RE: Murwillumbah Education Campus, 86 Riverview Street, Murwillumbah (SSD-16848913)

Enclosure: Attachment 1: Detailed BCD Comments – Murwillumbah Education Campus, 86 Riverview Street, Murwillumbah (SSD-16848913)

Figure 5 Bushfire Prone Land Mapping

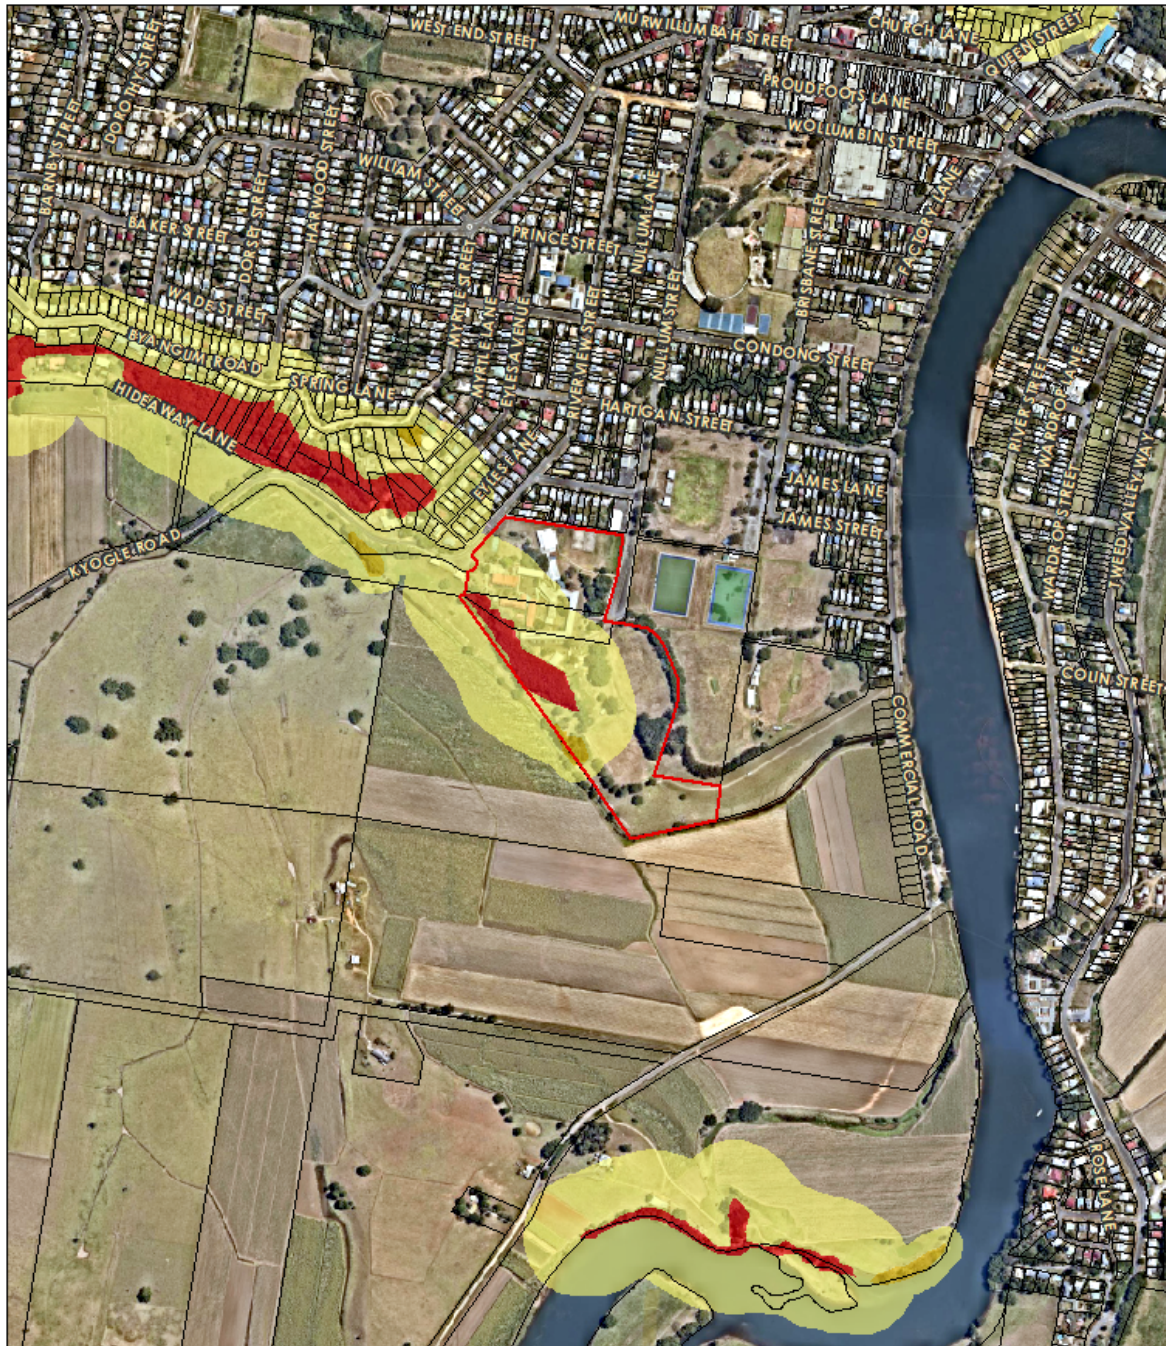
However, it is claimed in section 6.3 of the bushfire risk assessment that the mapped bushfire prone vegetation within the school boundary is less than 1 hectare in total area. However, the total area of mapped bushfire prone vegetation within the school boundary is approximately 1.3 hectares, which consists of 1.1 hectares of Category 1 vegetation and 0.2 hectares of Category 2 vegetation (refer to Figure 1).

3. The bushfire risk assessor should either amend the bushfire risk assessment to include further explanation and justification for identifying the hoop pine plantation as low threat vegetation or revise the bushfire risk assessment to include a bushfire APZ consistent with PBP 2019 between the proposed buildings and the hoop pine plantation.

Figure 7 Landscape Management Plan

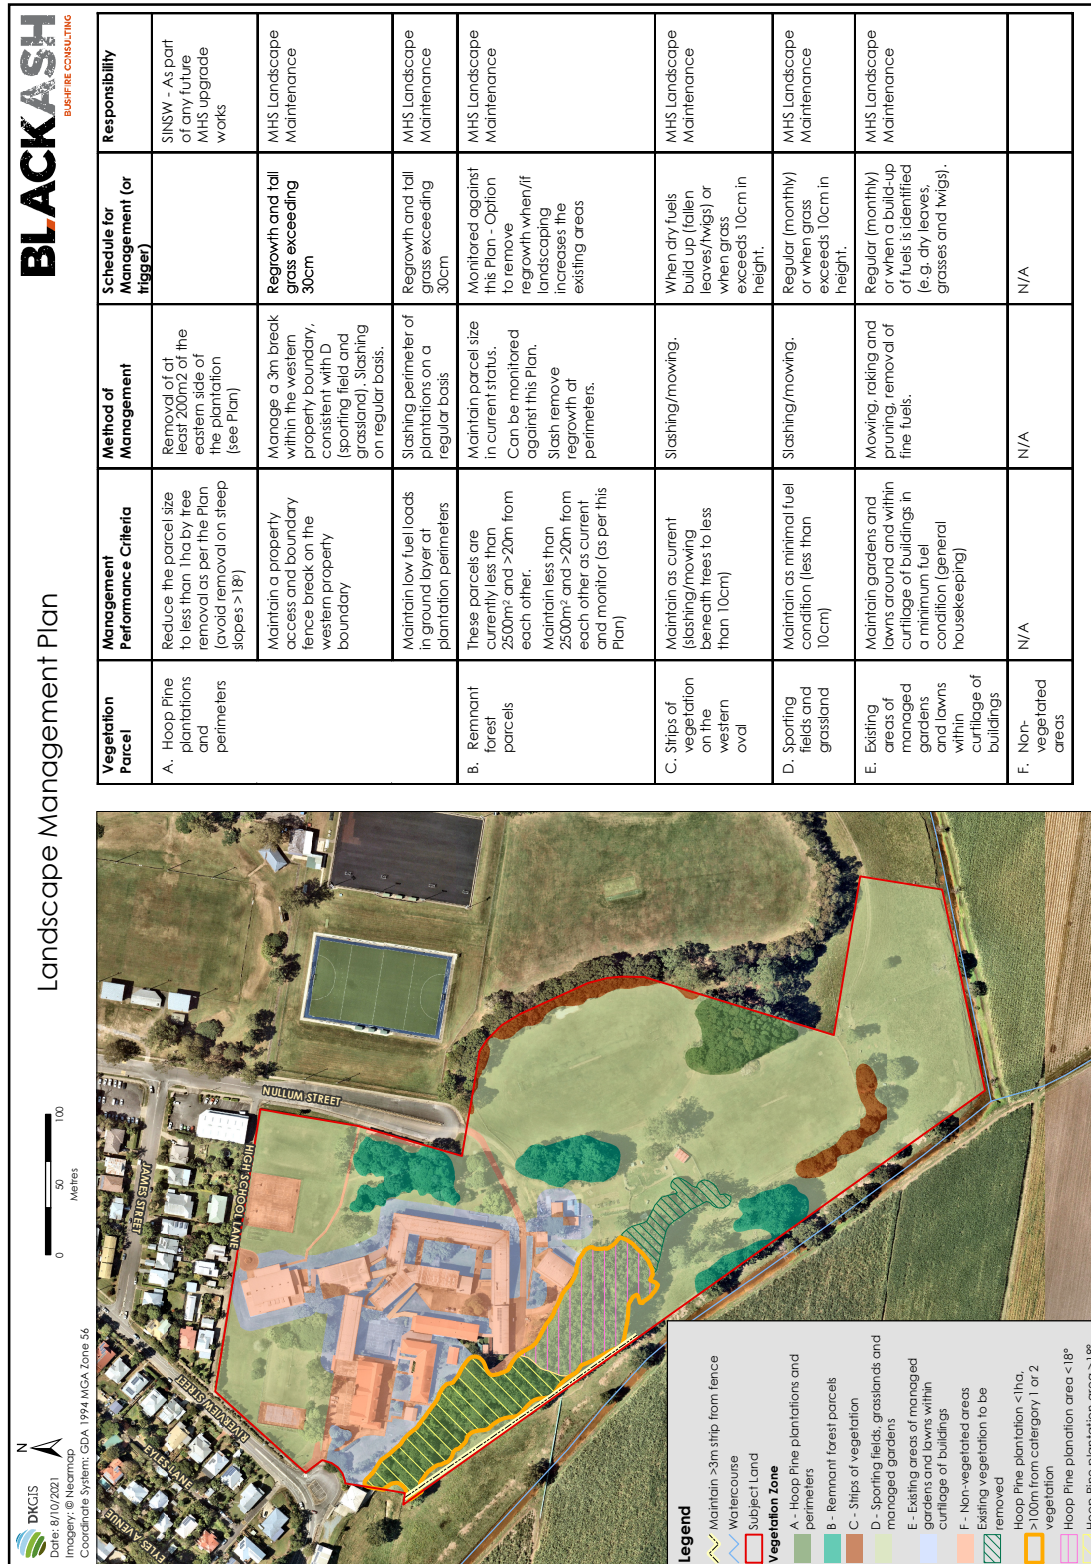
The landscape management plan provided in Figure 7 of the bushfire risk assessment outlines an intention to remove native vegetation from the south-eastern end of the Category 1 area specifically to reduce the forest remnant size to less than one hectare. However, even if the area of the forest remnant was reduced to less than one hectare, the resulting forest remnant would still be less than 100 metres from the remnant of Category 2 vegetation located south of the hoop pine plantation (refer to Figure 1).

It is recommended in Section 8 of the bushfire risk assessment to “*manage vegetation within the school grounds to APZ standards (plantation managed to less than 1 ha in area and as low threat vegetation/windbreaks) as per Figure 7*”. However, given the plantation has a dense tree canopy and a dense ground layer of thick leaf litter, simply reducing the area of the plantation to less than one hectare by removing 0.2 hectares from the south-eastern end of the remnant would not achieve APZ standards, which typically require tree canopy cover of 15% and 30% for inner and outer protection areas respectively and ongoing removal of leaves and vegetation debris from the ground layer.

Based on the proposed fire hazard reduction measures, the removal of 0.2 hectares of vegetation from the south-eastern end of the hoop pine plantation would be unlikely to reduce the speed or intensity of a bushfire that approaches the subject land from the west or southwest through the sugar cane plantation and pasture grassland. Furthermore, the northern half of the hoop pine plantation is situated on an upslope to the proposed buildings of greater than 18 degrees, which is likely to increase the speed and intensity of a bushfire approaching from the direction of the sugar cane plantation.

6. The bushfire risk assessor should revise the bushfire risk assessment to demonstrate how the hoop pine plantation would be managed to the standard of an Asset Protection Zone without impacting the habitat viability for the critically endangered flora species, *Rhodamnia rubescens*, occurring within the hoop pine plantation.

7. The BDAR and landscape management plan should be revised to include mitigation and management measures aimed at maintaining and protecting *Rhodamnia rubescens* and its habitat on the subject land during the operational phase of the project.
